J.J. & C.B. Dunn
c/o Locked Bag 7
WAUCHOPE NSW 2446

11 December 2019

RE: Hanson Sancrox Quarry SSD Application No. 7293

"D"

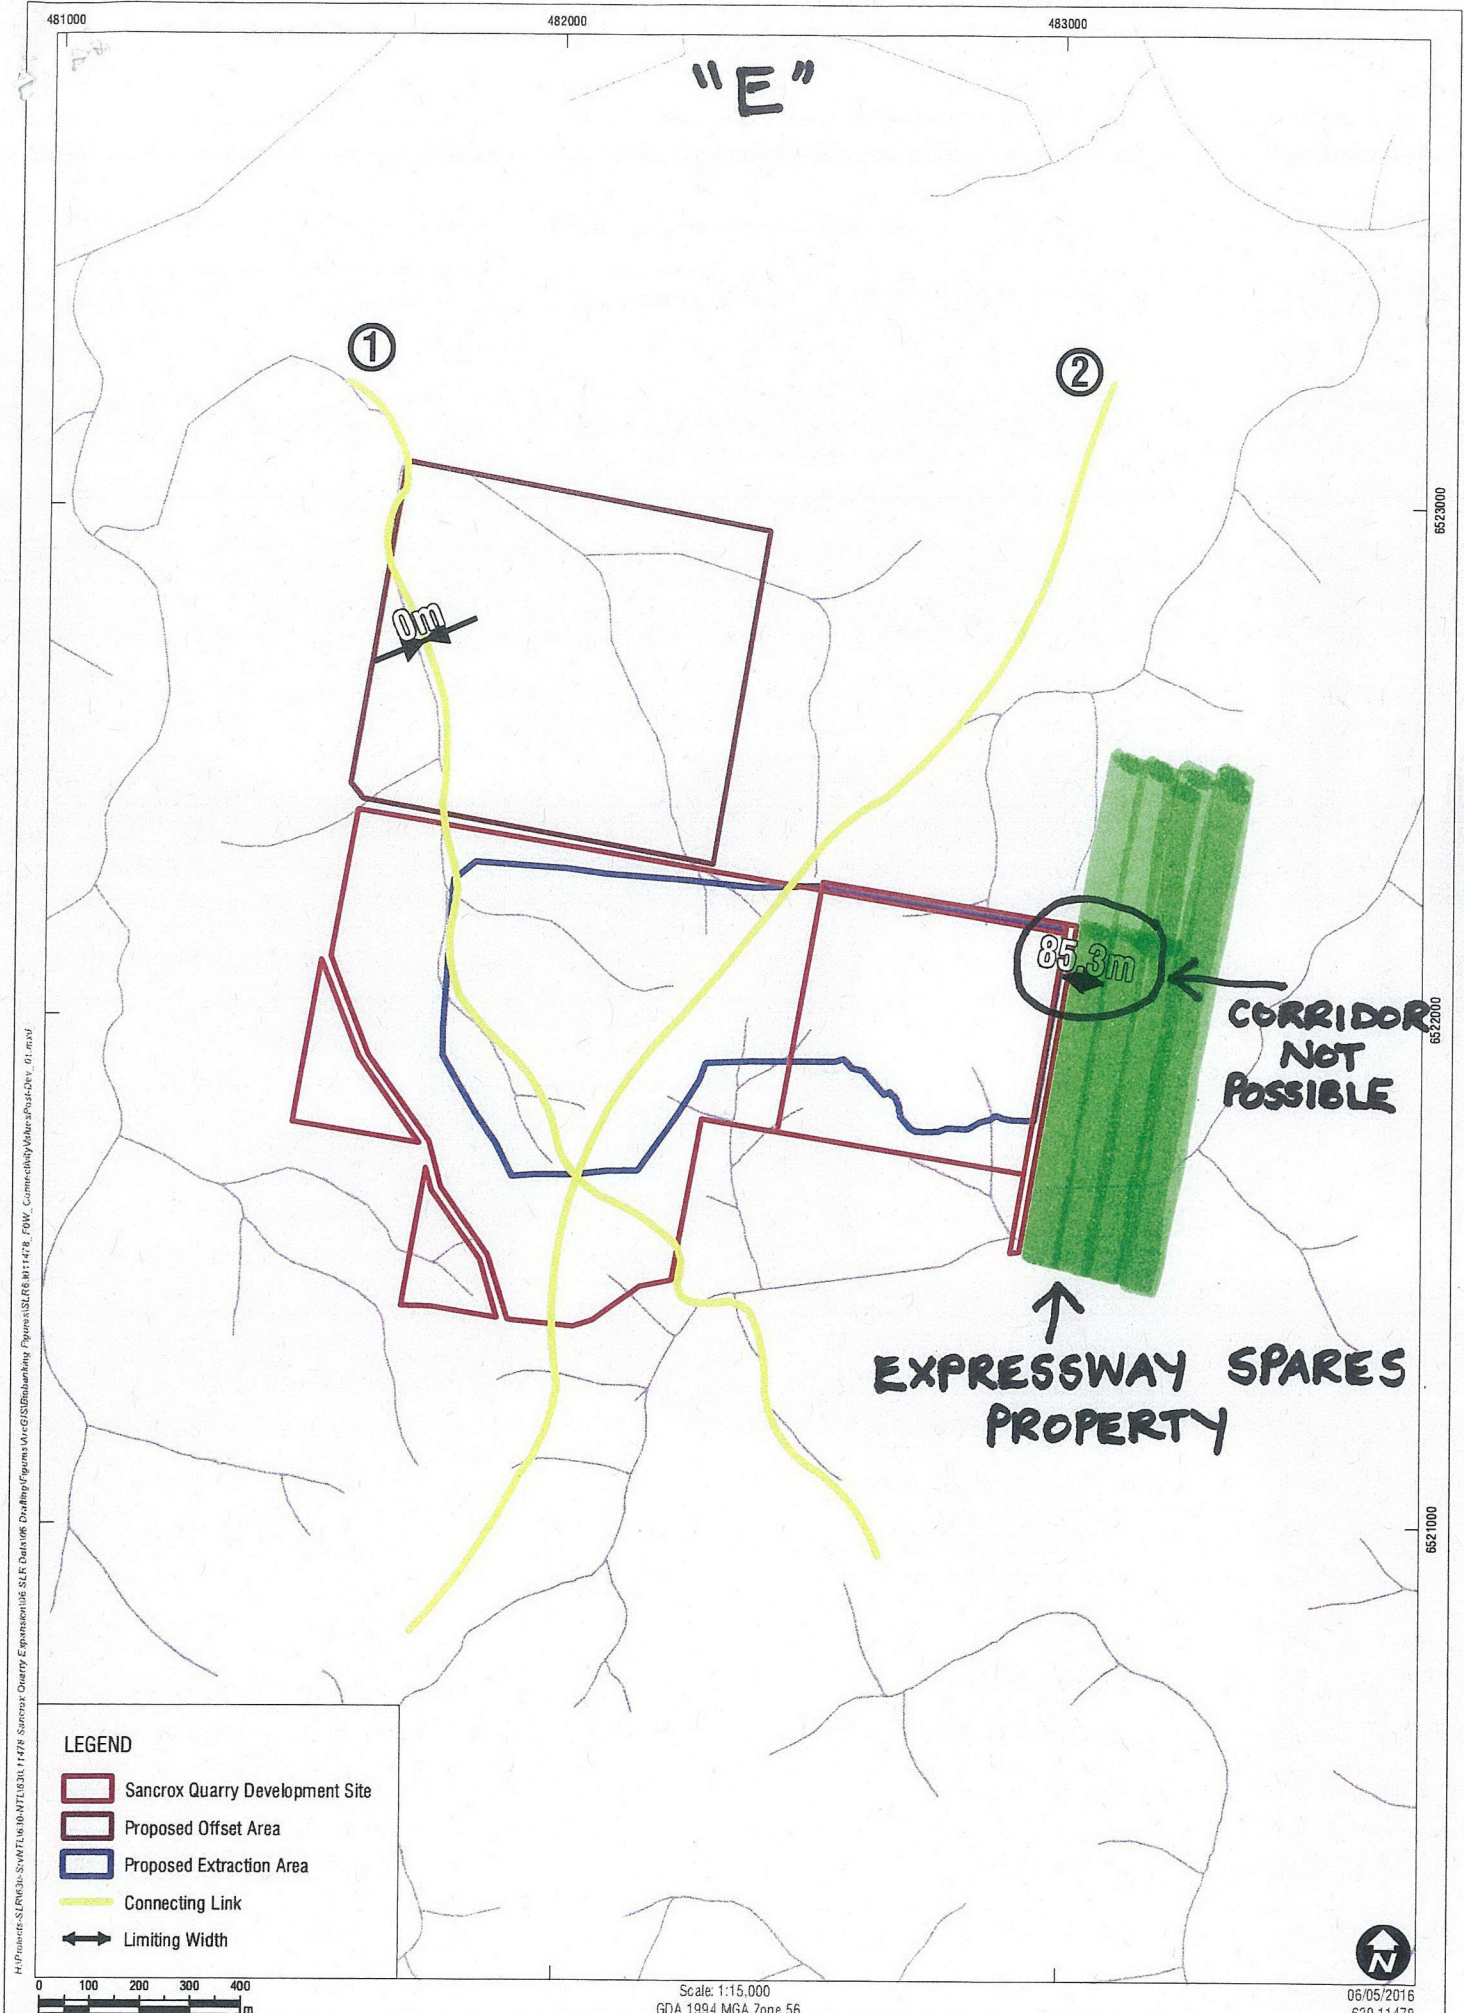
This is one issue that has caused us a lot of grief over the years. The existing 'sales floor' or area that stores the crushed rock at the quarry has been artificially filled over a number of years.

It is now some 5 metres above existing ground levels and depending on the prevailing weather/rain, we get large volumes of stormwater runoff that goes for days and weeks after large rain events.

Attached at "D" is a section completed by our consultants King & Campbell showing how the run-off issue has been created over time.

We submit that there be engagement with us to resolve an agreed outcome regarding this stormwater issue on our property as part of this DA assessment.

**Connectivity Value - Post Development Site**  
**Connecting Links**  
**(Current linkage widths)**

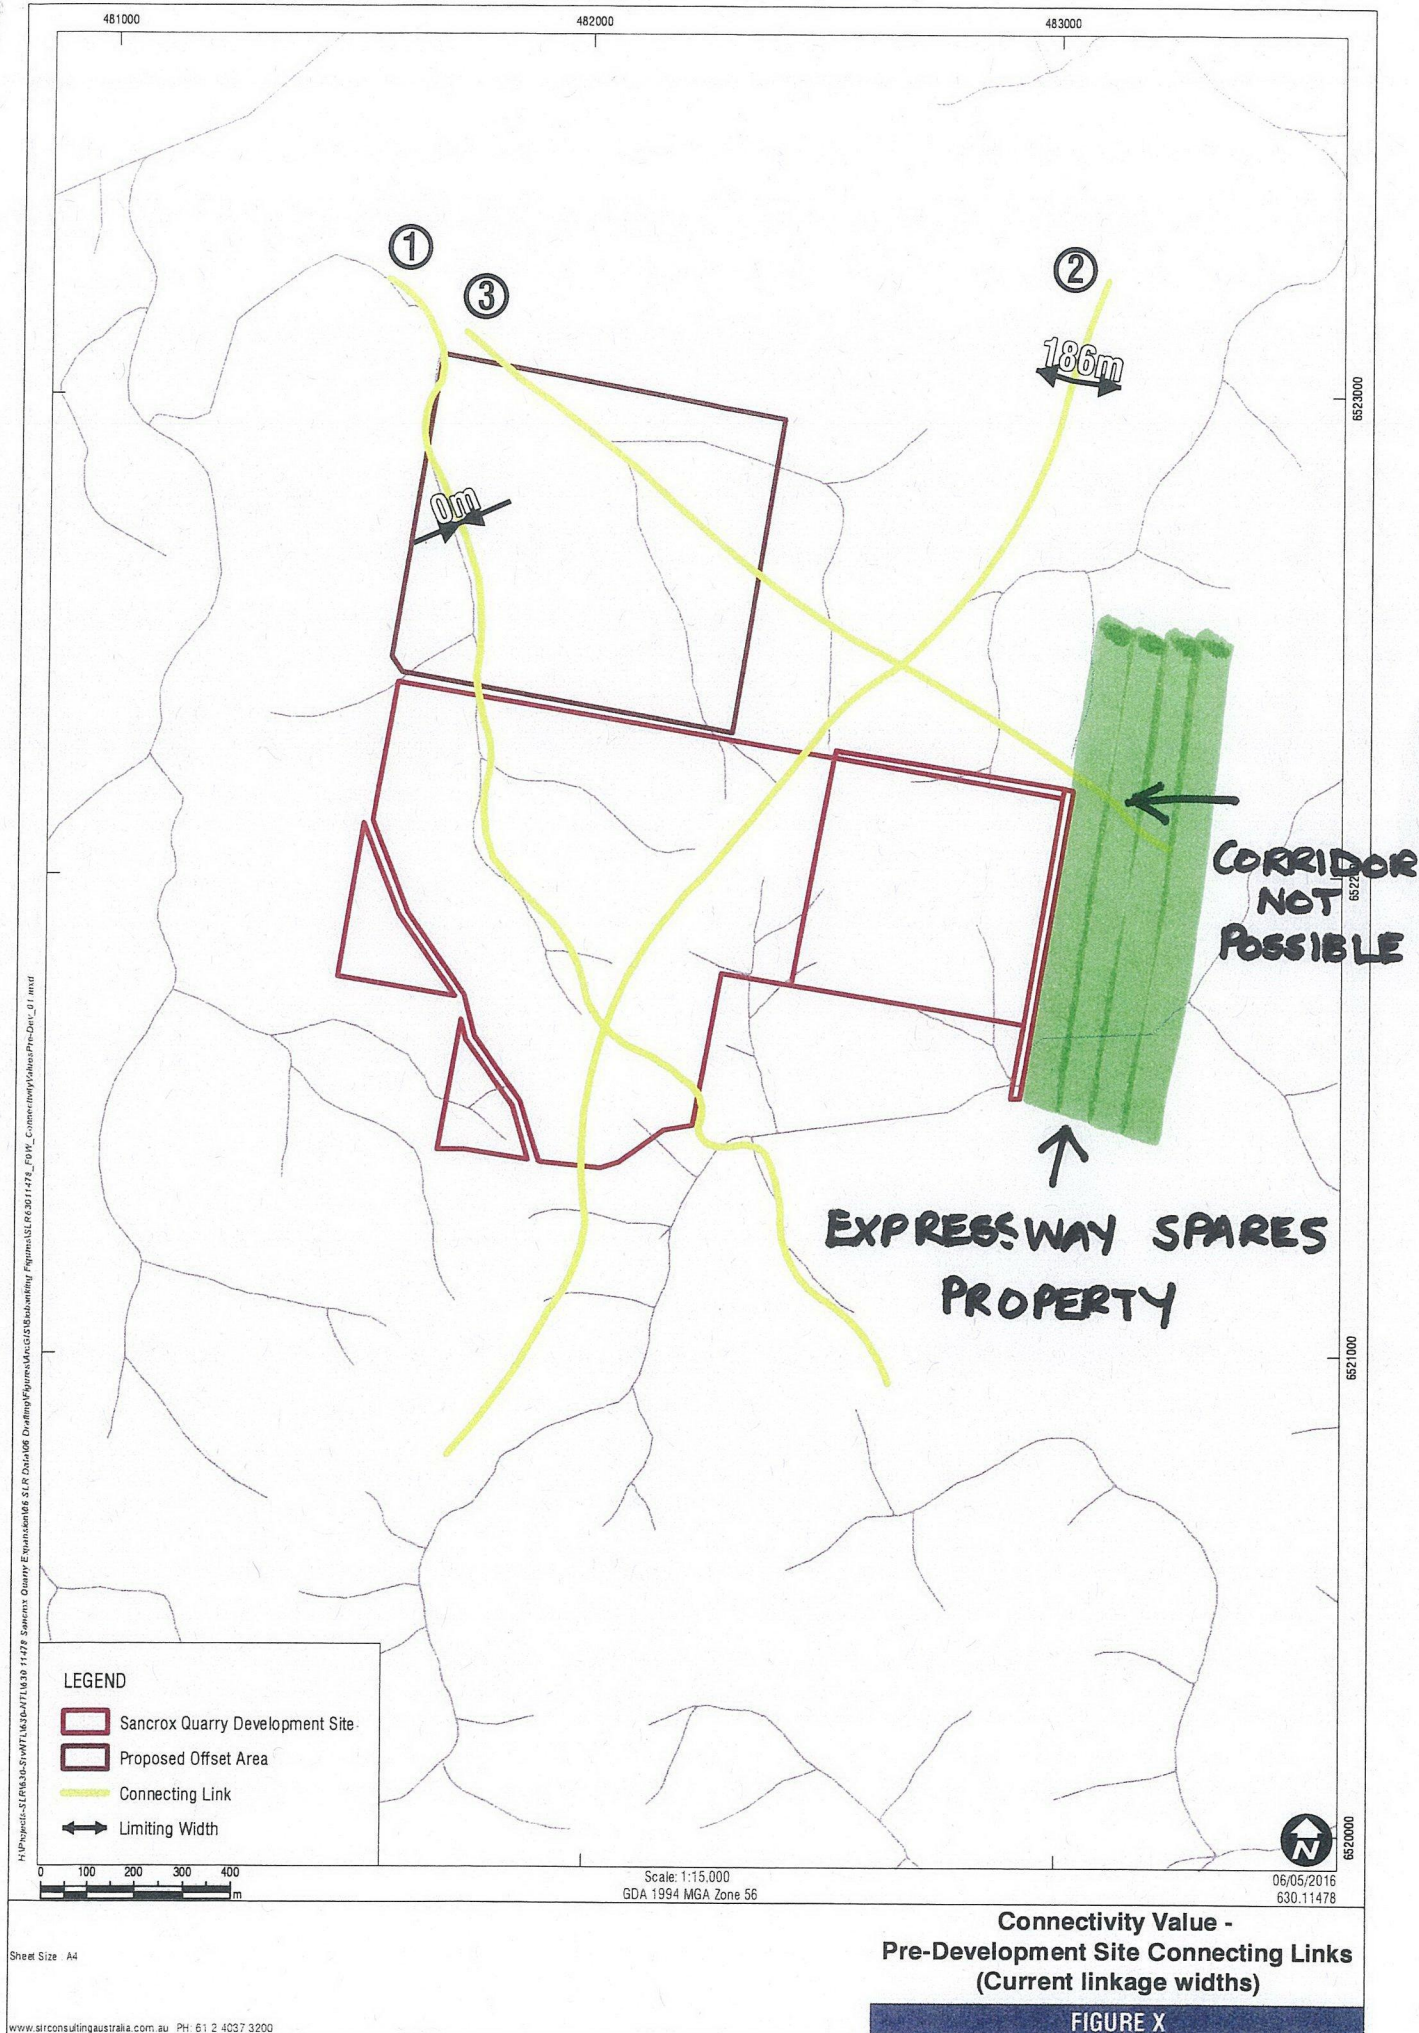
The connectivity plans or corridor plans (marked-up copies attached at "H") created by SLR show a distinct lack of understanding of what is already approved and what is reality on neighbouring properties.

There is no long-term ability for a corridor through the middle of our industrial subdivision. This needs revision.

There is no ability for a corridor on Expressway Spares property and that would be obvious by the approvals in place and what is 'on the ground' at the moment.
